Response to Comments

Project Name: Quality Auto Center
 Project File Number: PA22-005
 Review Completion: July 25, 2022

PRELIMINARY SITE PLAN

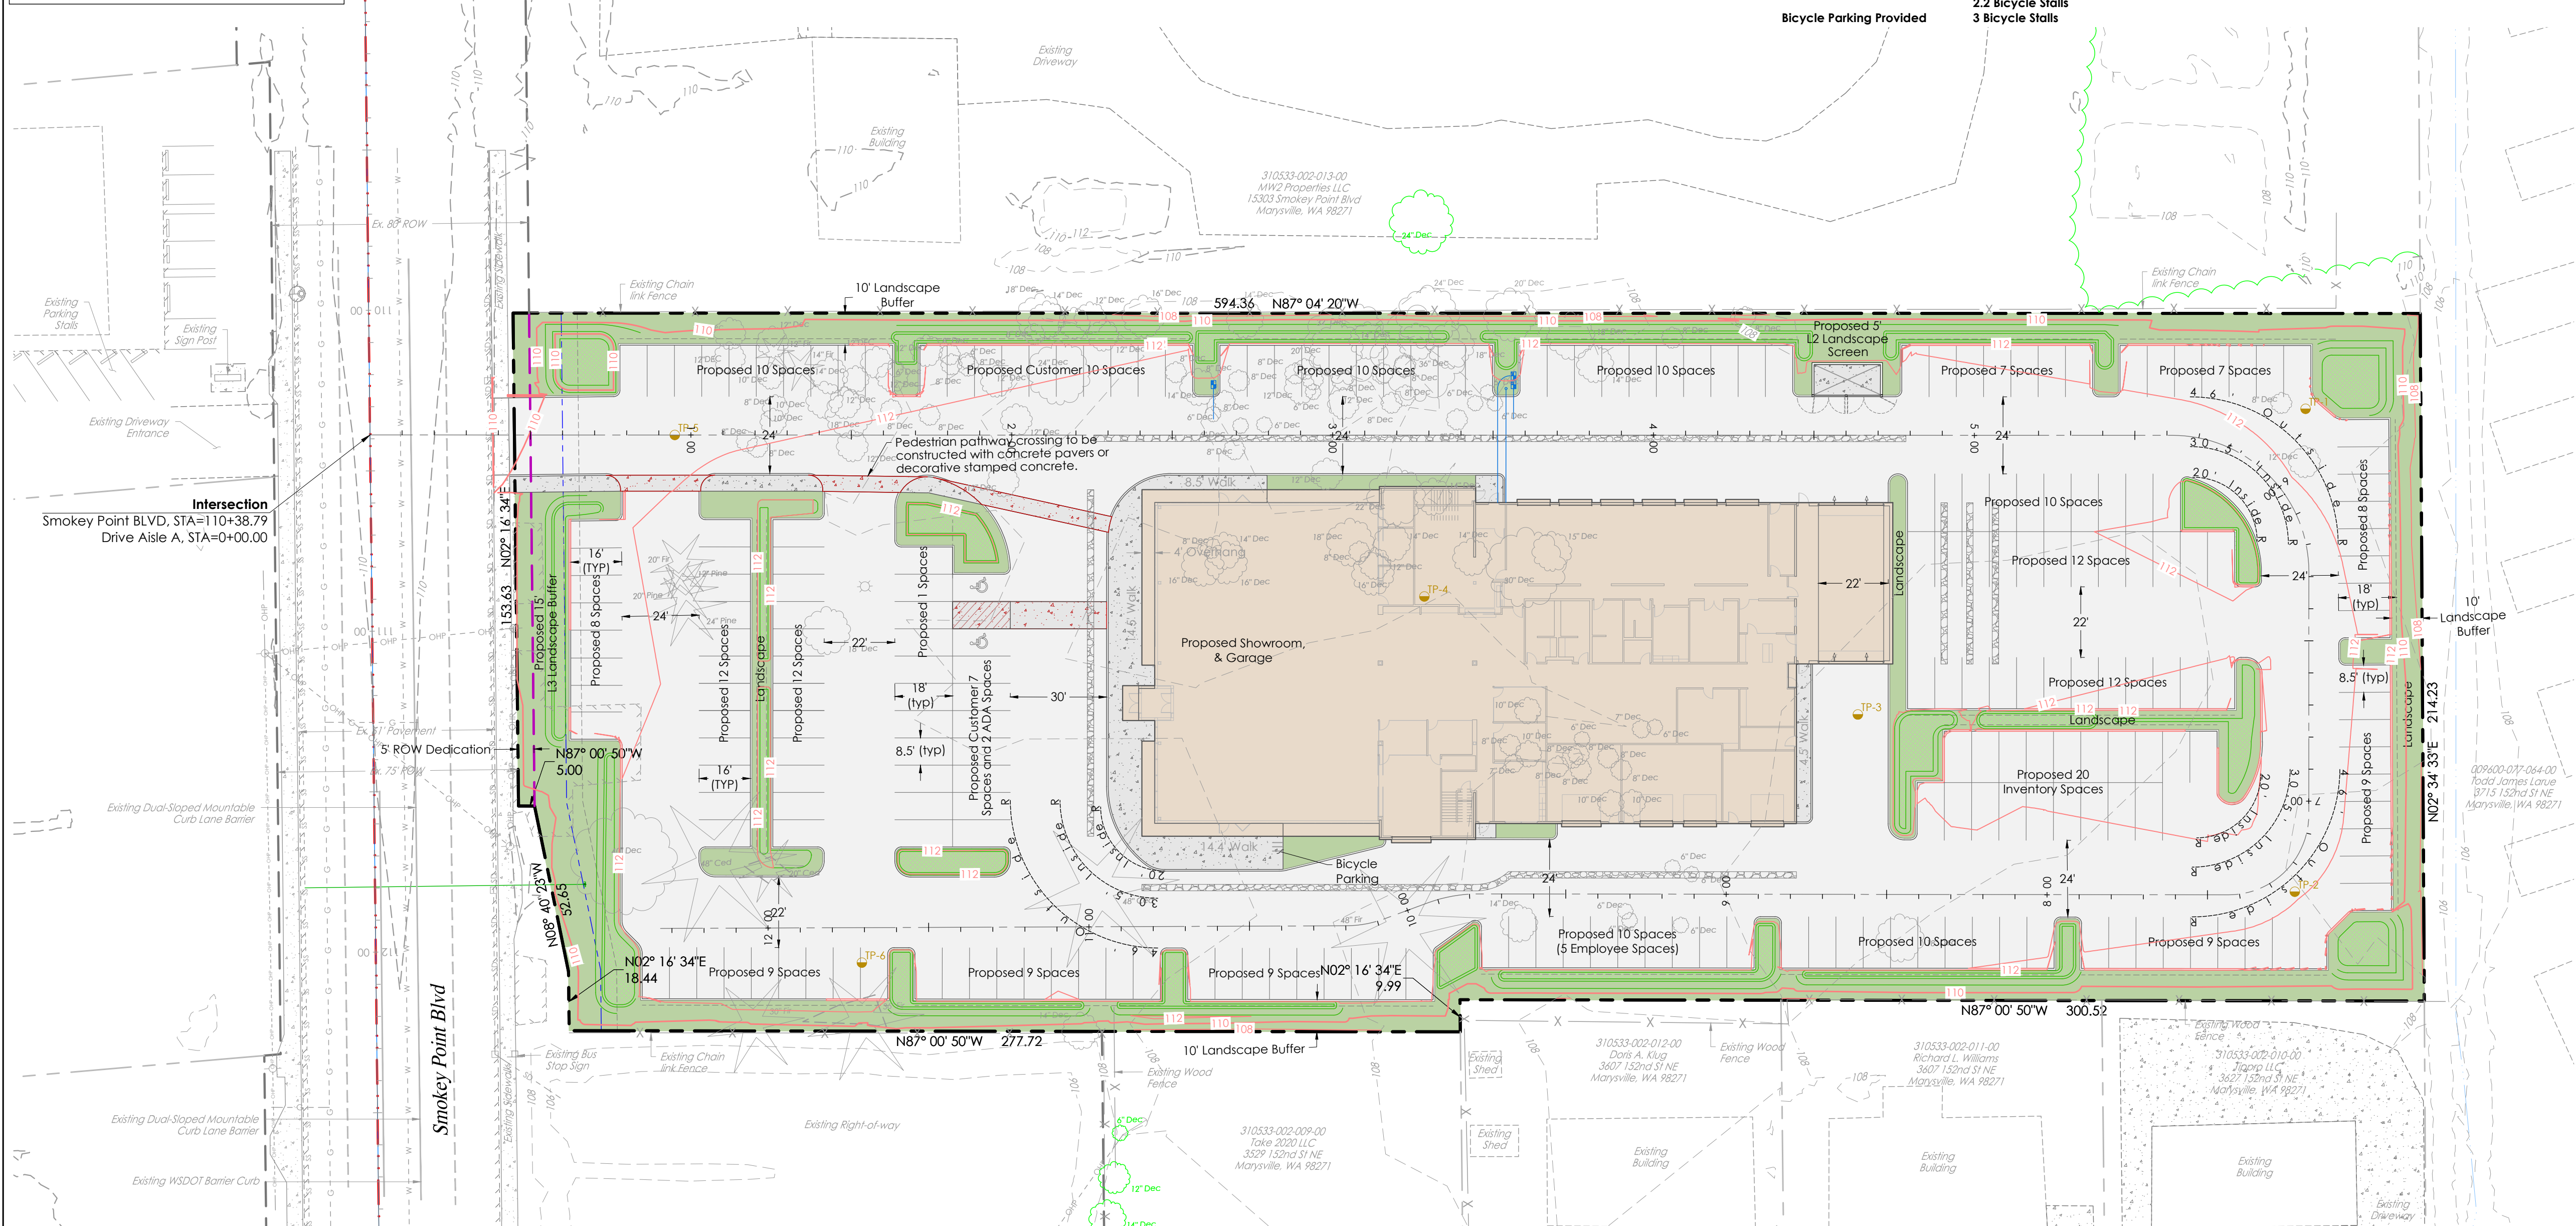
CITY COMMENTS	LAND TECH RESPONSE
Community Development: Reviewer: Chris Holland, Planning Manager	
<p>1. Sheet P1 shall be amended, as follows (see attached redlines):</p> <p>a. The pedestrian connection shall be relocated to align with the front entry to the showroom to the sidewalk. Pursuant to MMC 22C.130.050(5)(c), the pedestrian pathway shall be constructed with decorative concrete and physically separated from vehicle traffic and maneuvering areas.</p> <p>A minimum 5' landscape islands shall be provided on either side of the pedestrian pathway as it traverses through the proposed parking spaces and/or inventory lot.</p>	<p>TR 1 Response: a.) pedestrian connection cannot be made at midpoint of the property frontage and have the required fill material to provide separation from groundwater. The Elevations here do not work.</p> <p>130.050(5)(c) requires that pedestrians and wheelchairs easily gain access from Public Streets... to building entrances through use of raised concrete or pervious pavement sidewalks..., or pedestrian paths which are physically separated from vehicle traffic...</p> <p>We are proposing the use of pervious pavement dyed brick red and not optioning for the "or" separated path.</p> <p>We do provide landscape on the side of the walk as it crosses landscape areas and do not see in code where the 5' landscape islands on either side of the path are required. Five foot landscape islands are not included in MMC 22C.130.050(5)(c).</p> <p>b.) turning radii are included through the fire lane route to show compliance with the standards. This is located on Sheet P1- Site Plan.</p>

CITY COMMENTS	LAND TECH RESPONSE
<p>TR2 Comment: As noted in MMC 22C.130.050(5)(c), developments <i>must</i> provide specially marked or paved walkways through parking lots, as depicted in Figures 1 through 4. Figures 1 through 4 clearly show landscaping within tree grates, which would require a larger width pathway, or landscape islands. The 5' landscape islands adjacent to the walkway referenced in the TR1 comments are required in accordance with MMC 22C.120.130(5)(b) & (c), based on the location of the required walkway. Additionally, the walkway proposed is not physically separated from vehicle traffic and maneuvering areas and must be raised and constructed similar to a public sidewalk. All of the auto dealerships constructed on the north end of the city within the GC have complied with this provision. The TR1 comments still apply and the site plan shall be amended to meet these conditions.</p> <p>b. Amend SIGNS language to read as follows: All signs <u>shall</u> are to comply with MMC <u>Chapter 22C.160 Signs</u> 22C.160.160(1).</p>	<p>TR2 Response: Site Plan has been updated with 5-ft landscape on either side of walk. This has been accepted by Chris Holland in email correspondence with Lance Mueller, Architect.</p> <p>b.) Notes updated to read Chapter 22C.160 <u>SIGNS</u> (for a second time 😊 and confirmed it has been changed this time.)</p>

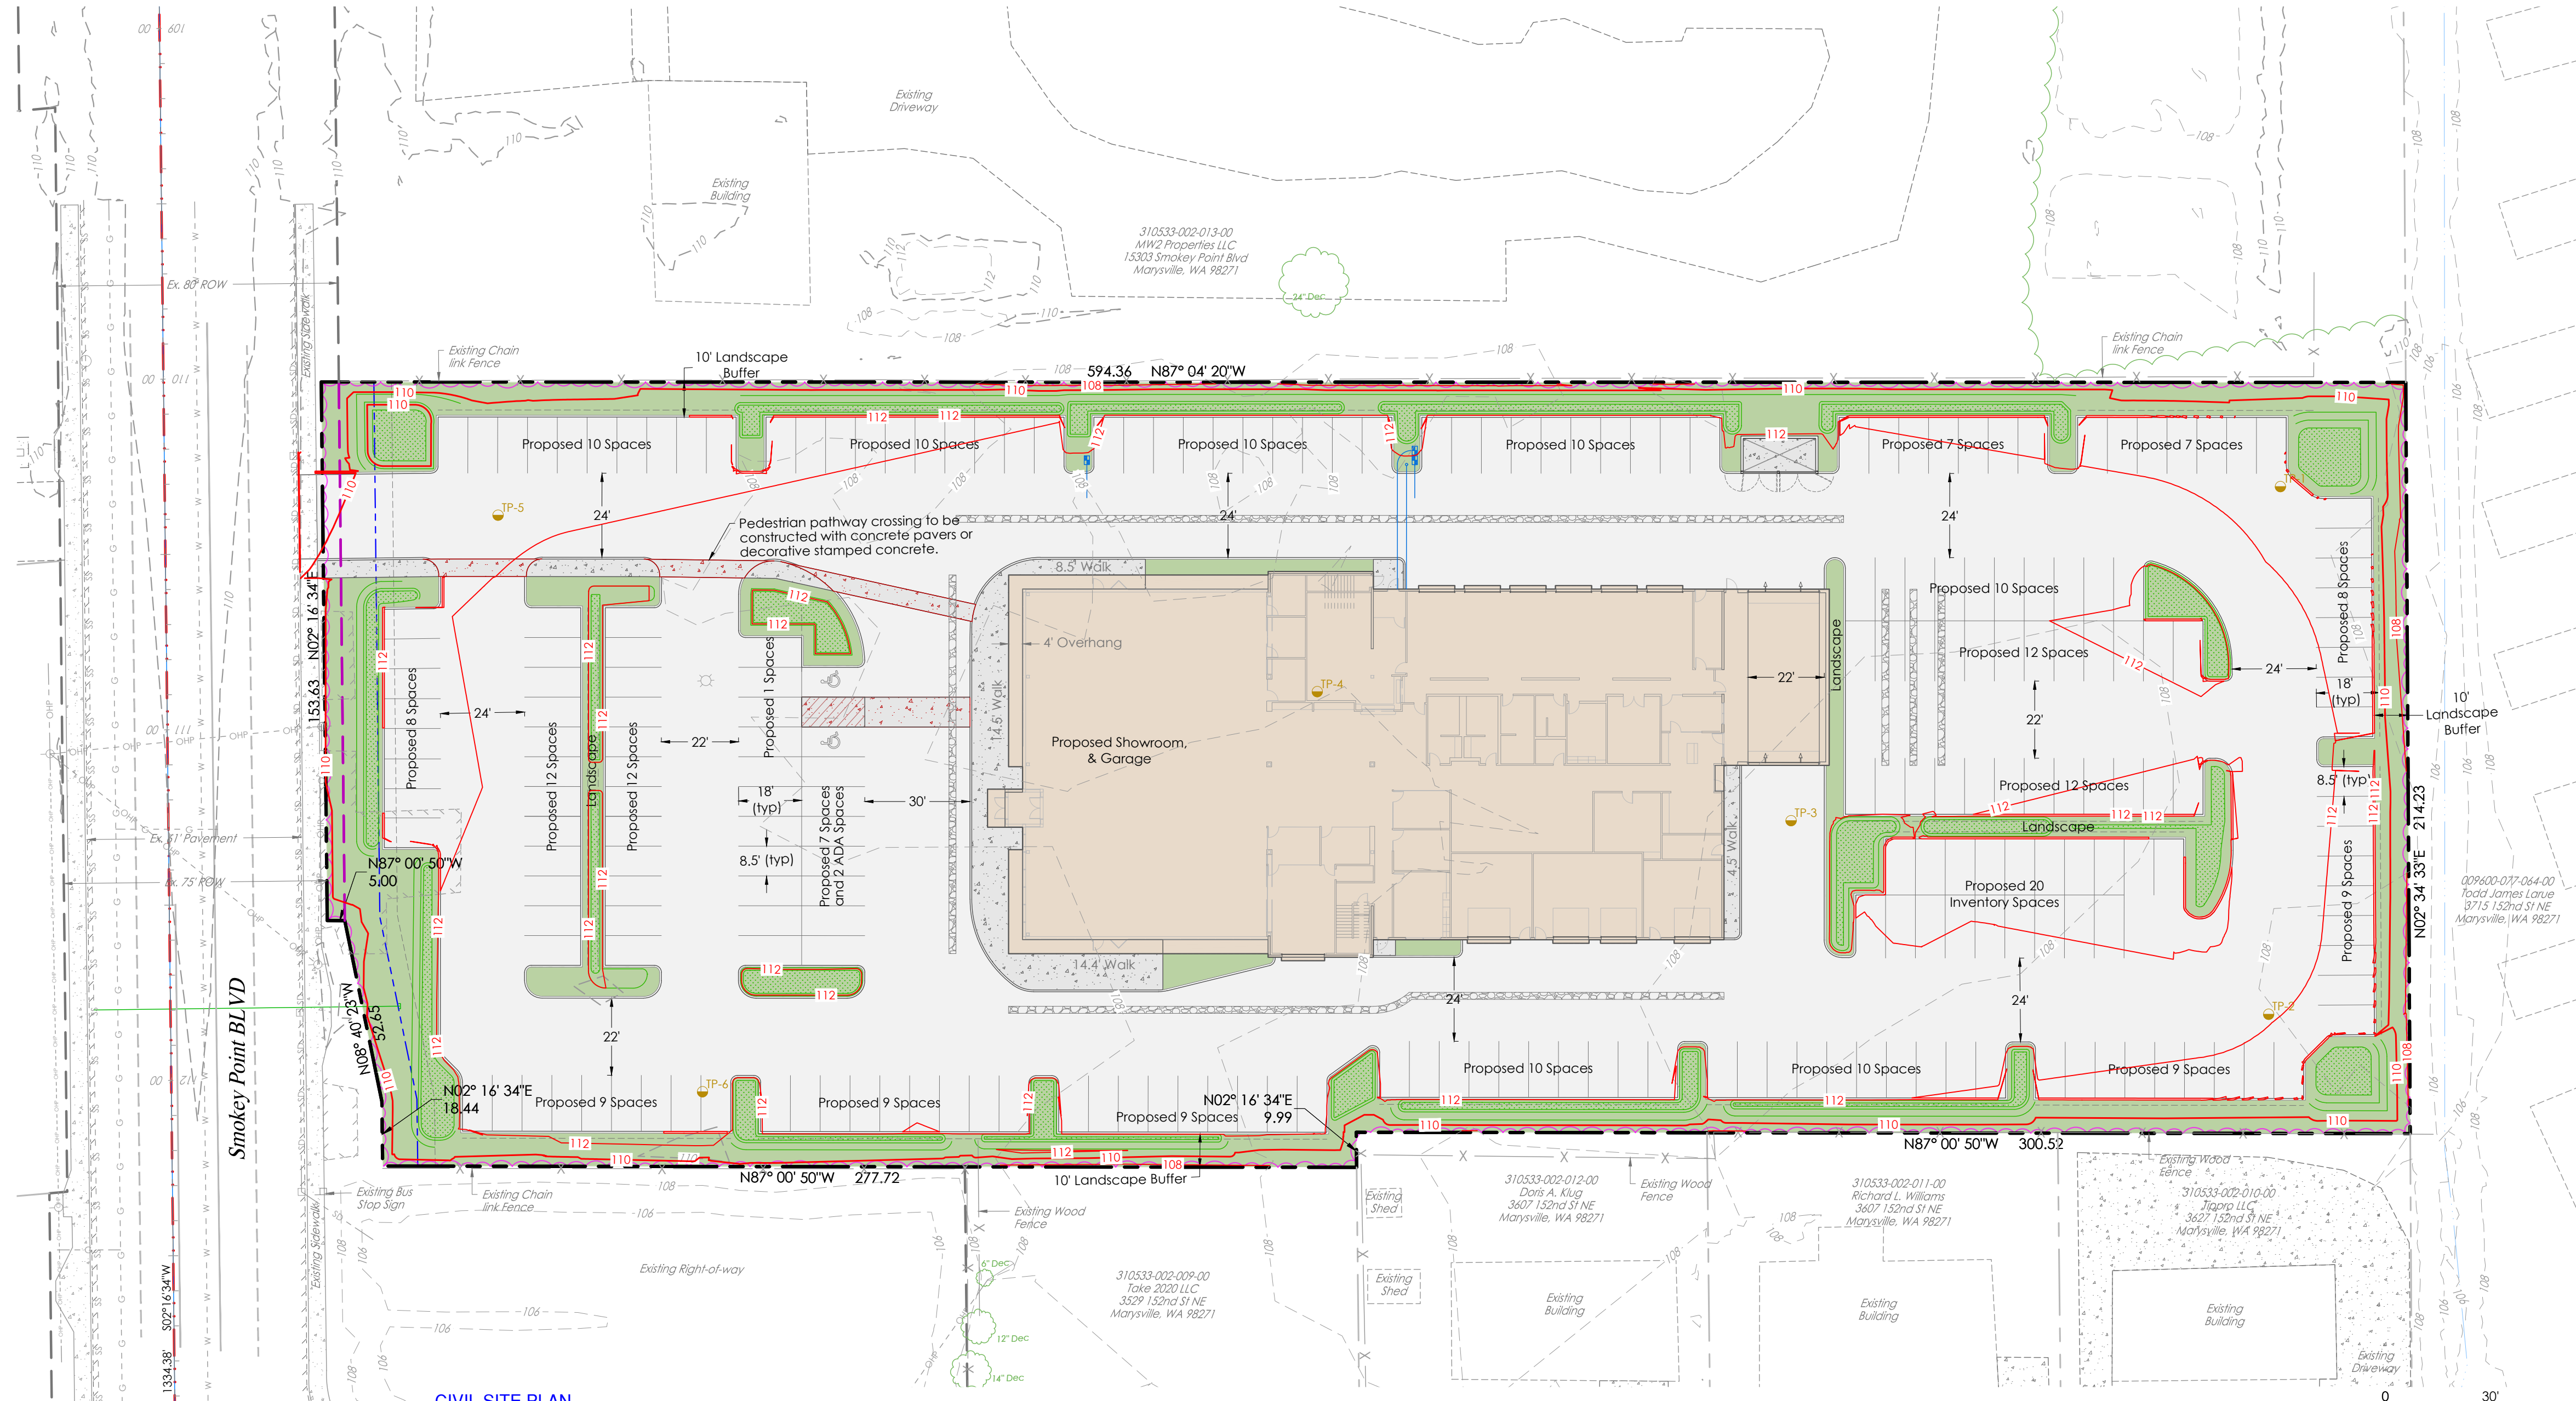
4. <u>Dedication Requirements:</u> a. It does appear that a 5 foot dedication is required for Smokey Point Blvd.	5' dedication shown on plans. The Dedication is identified on the P1 - Site Plan. The C1- Site plan has this identified as a Magenta line but was not labeled on previous submittal. The C1 Site Plan will show this dedication on the Civil Construction plans.
